Your Ref: OWPC649
Our Ref: LY/10/13/ 20-05-2013
Please ask for:
Mr D Sullivan

Retention of 1.83m fence, concrete post, feather edge panels at the front of the property.

Old Vicarage Cottage Lyminster Road Lyminster

MISS S POLLOCK
OLD VICARAGE COTTAGE
LYMINSTER
FENCE ELEVATIONS
SCALE 1-200

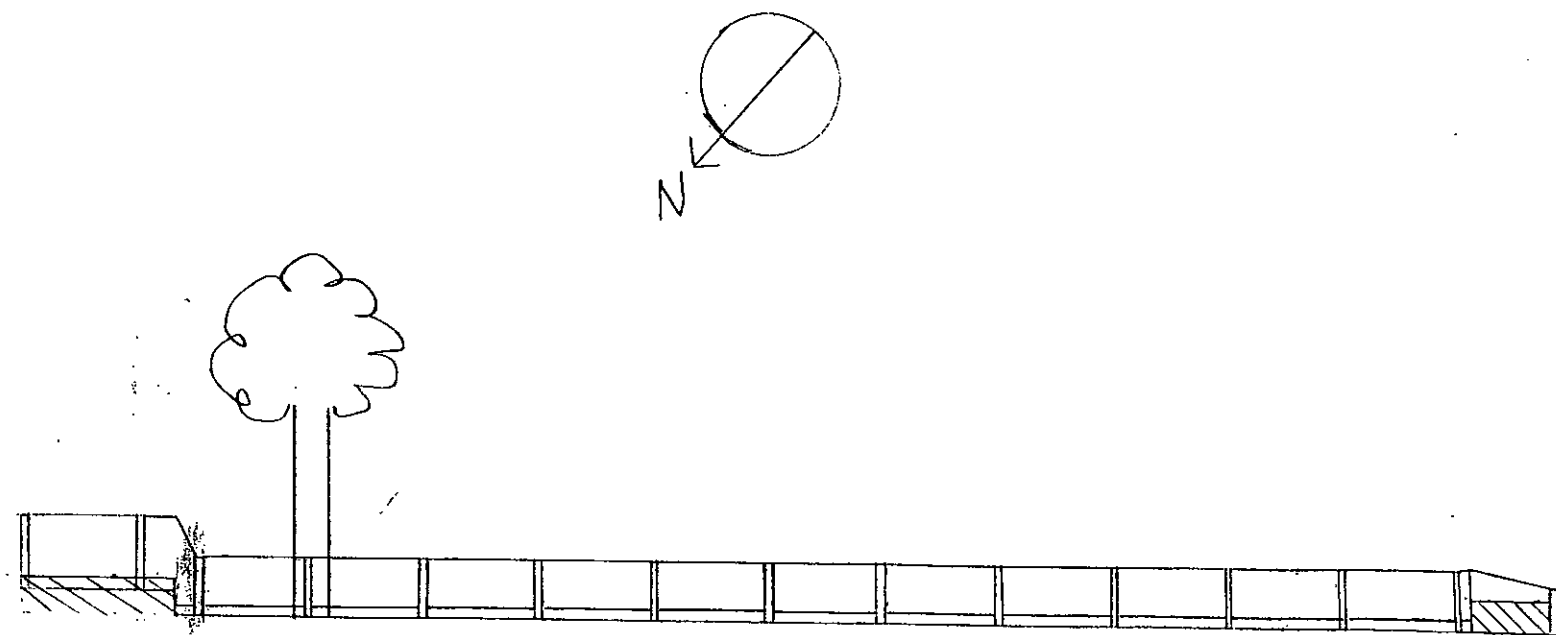
*The property abuts a sharp road bend on the Lyminster Road.
The fence provides a visual and acoustic barrier against traffic noise to the residents.
Importantly it also provides a physical barrier against vehicles unable to negotiate the road bend.*

However, the fence is large, high and has a very significant visual impact within the Lyminster conservation area.

As a local resident I would ask that a condition for approval for the fence is that it is made to blend into its rural context i.e. maintained planting (Roadside) or a surface treatment to obscure the un-contextual (non-rural) vertical feather boarding and break up the visual massing of the fence.
